**MAJOR PROJECT ASSESSMENT:
Stages 2 and 3, Site 3 Mixed Use
Development
Australia Avenue, Sydney Olympic Park
(MP 10_0027)**

Director-General's
Environmental Assessment Report
Section 75I of the
Environmental Planning and Assessment Act 1979

January 2012

BUILDING SEPARATION

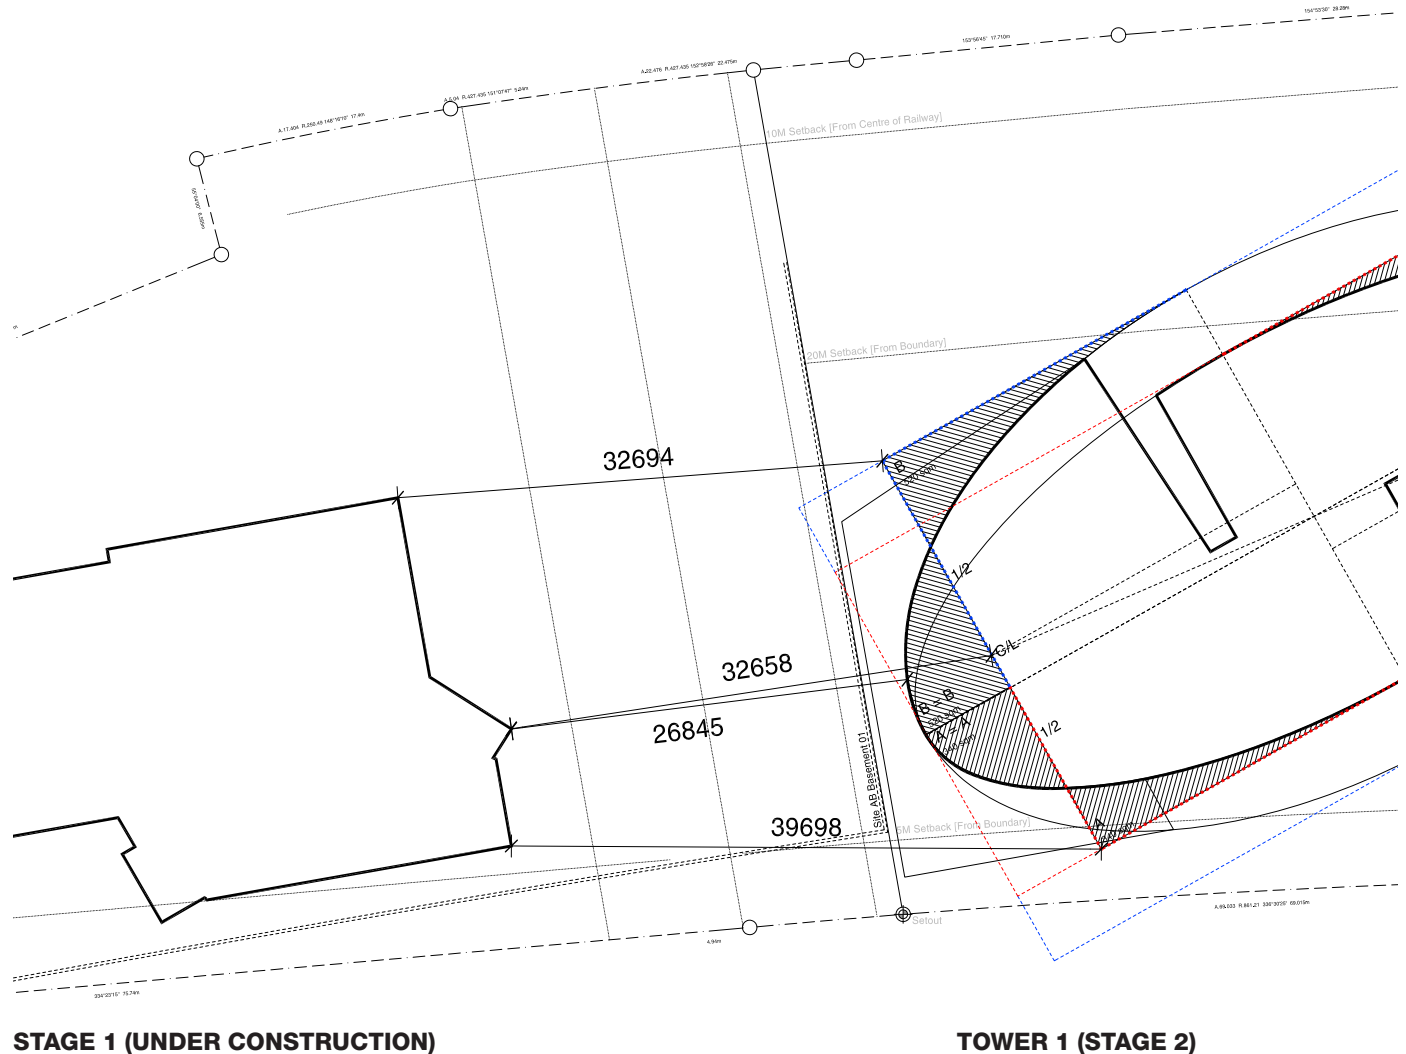
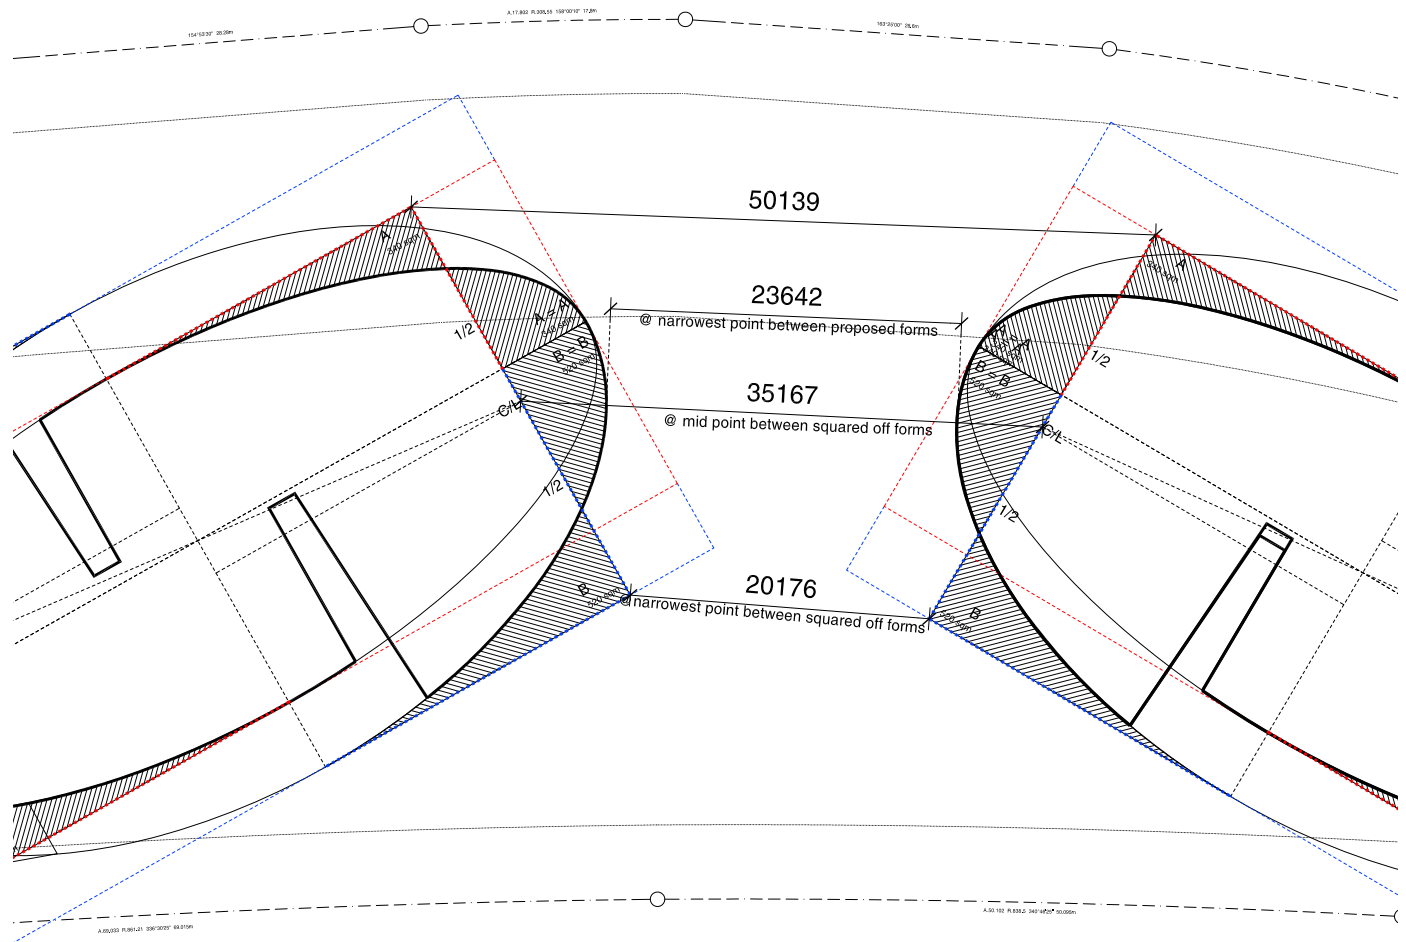
- further details regarding building separation between Stage 1 and Stages 2/3 is required
- the rooftop services zone shall be revised to comply with Master Plan 2030 requirements

Point 18 - Configuration of the vertical slots

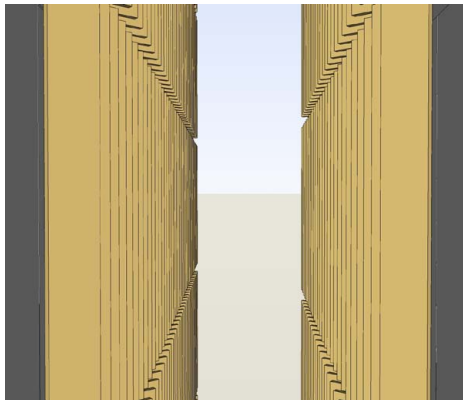
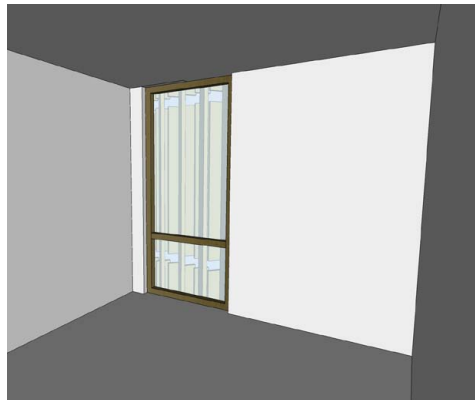
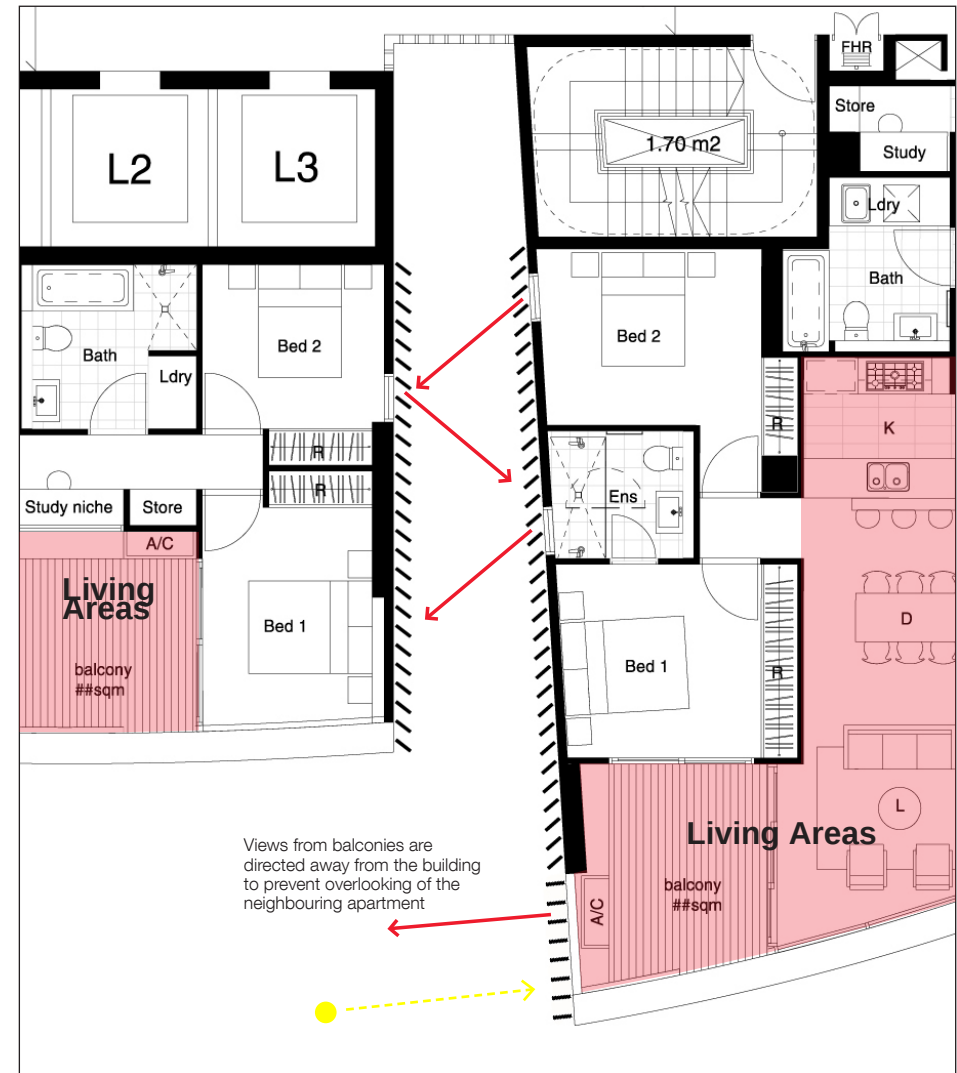
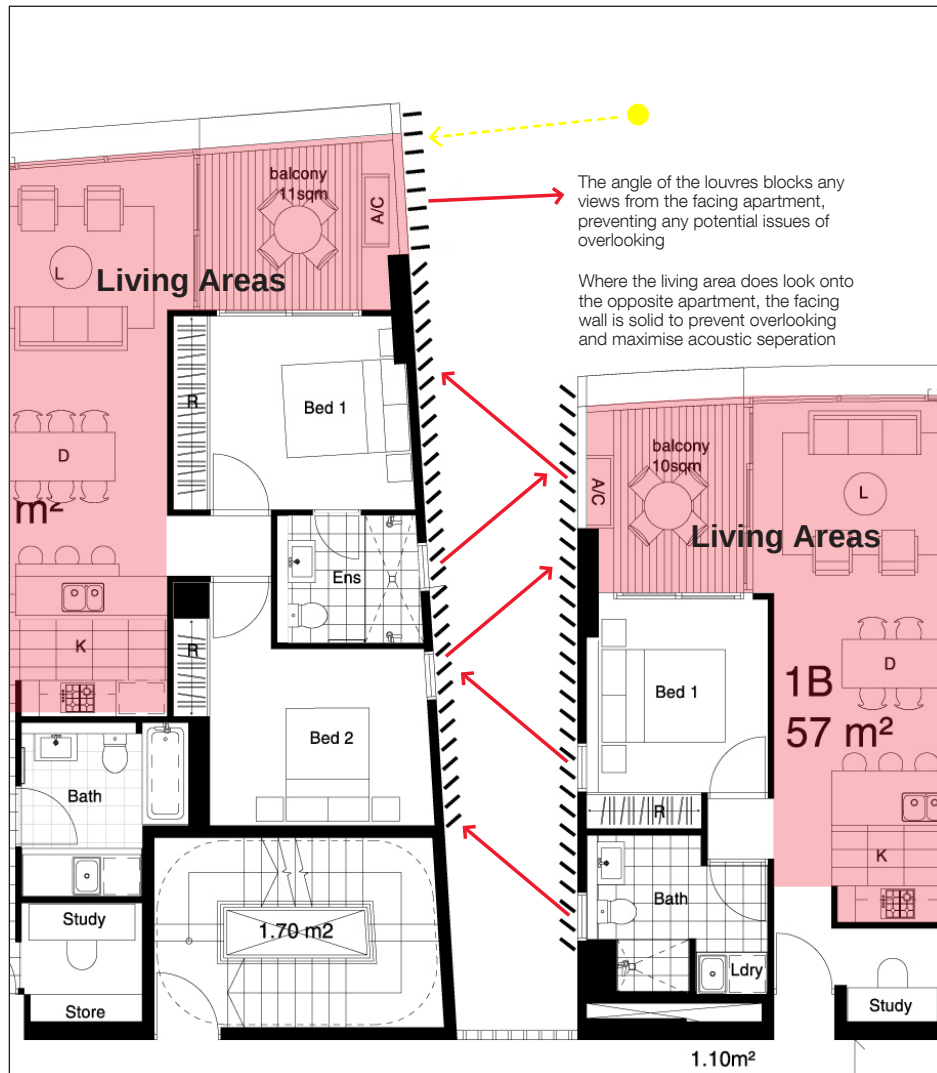
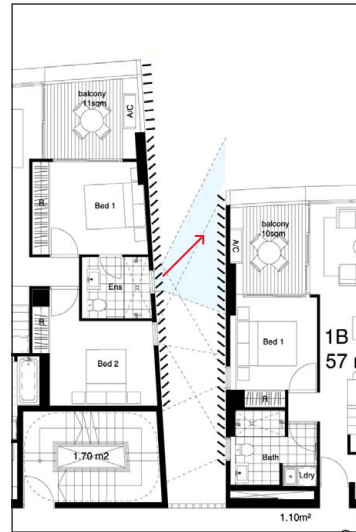
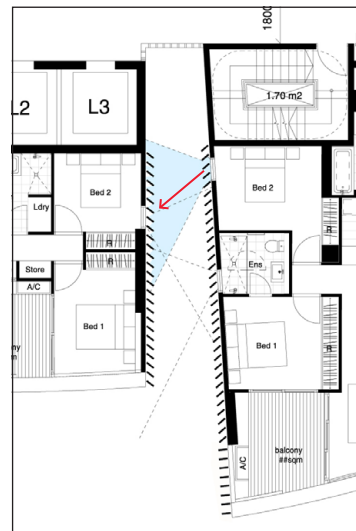
- reconfiguration of the vertical slots to increase the separation to provide better amenity outcomes for the habitable rooms that are located along the slots

Point 20 - Curtain Glass Wall

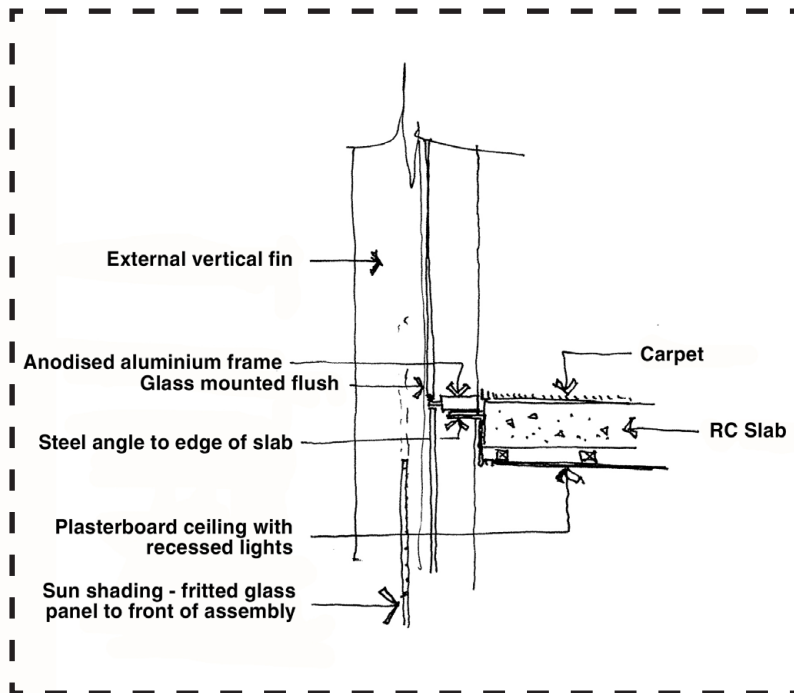
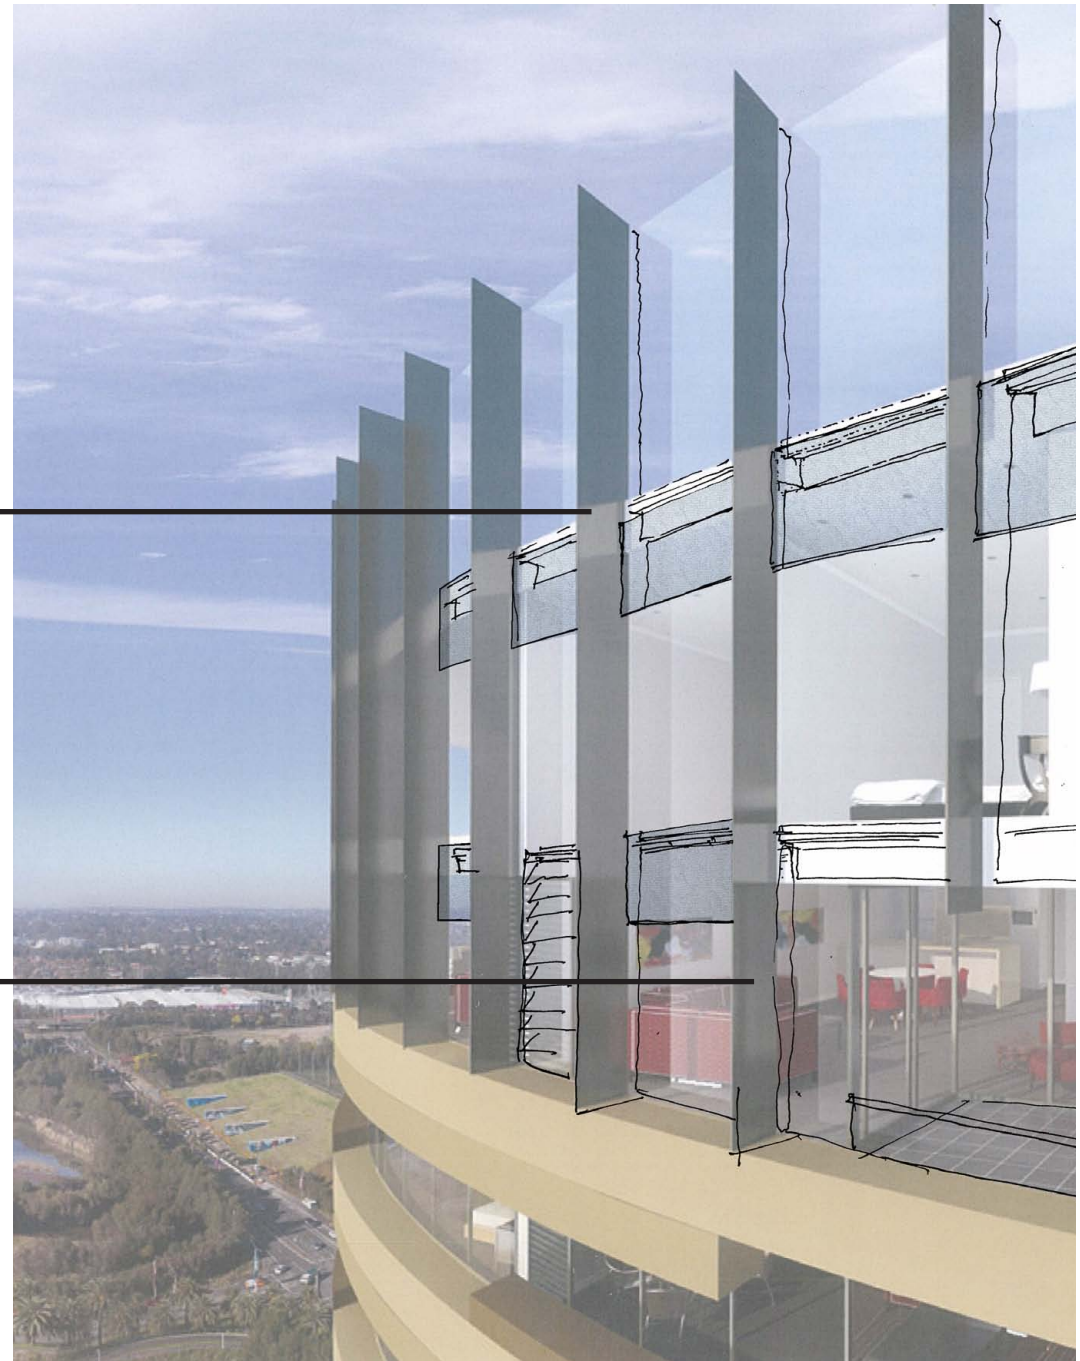
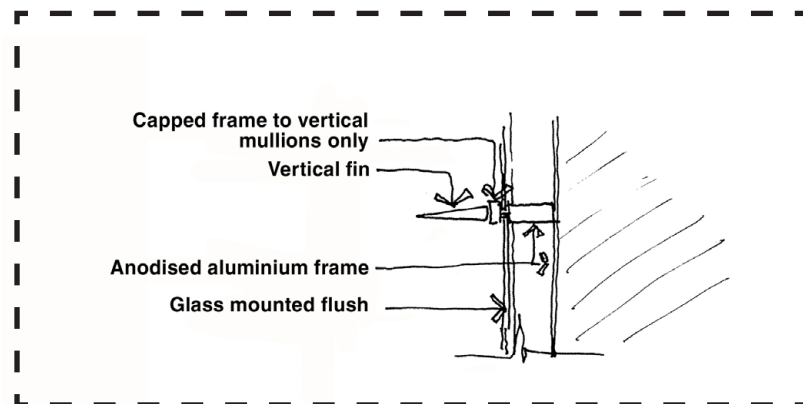
- a materials and samples board is required
- further details regarding sun shading and natural ventilation shall be provided where the façade of the upper units is a curtain glass wall
